Wednesday, 4th June, 2014

Ms Margaret Kirton
Mining Industry Projects
Department of Planning and Infrastructure
GPO Box 39
SYDNEY NSW 2001

Angus Place Colliery Project Approval 06_0021 Modification 4, the extension of First Workings approved by Modification 2

The Colong Foundation for Wilderness

Figure 4: Approved and proposed first workings in the extension area

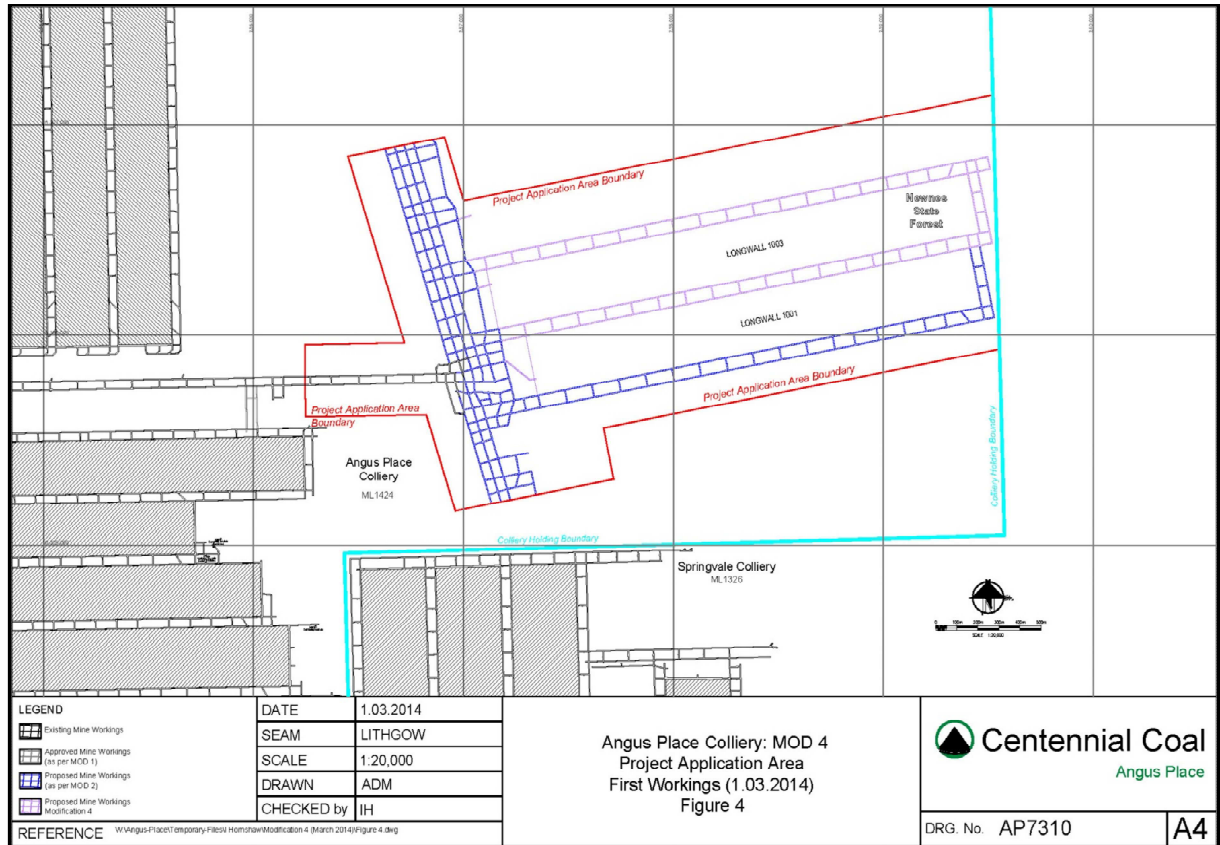
The Colong Foundation is pleased that the Department did not allow the “trial mining” to define the width of longwall panels in the 395 hectare proposal area.

This approved ‘trial mining’ in blue is much larger than the current proposal for first workings that will determine the longwall panel widths

The proposed development of underground roadways for longwall panels 1001 and 1003 pre-empts any subsequent limitations of mine subsidence impacts on surface features as changes to panel width are not possible if Modification 4 is approved.

The proposed longwall panels are WIDER than those previously approved. The longwall mining of panels 1001 and 1003 will lead to GREATER environmental damage as the proponent moves east into the more sensitive Carne Creek catchment.
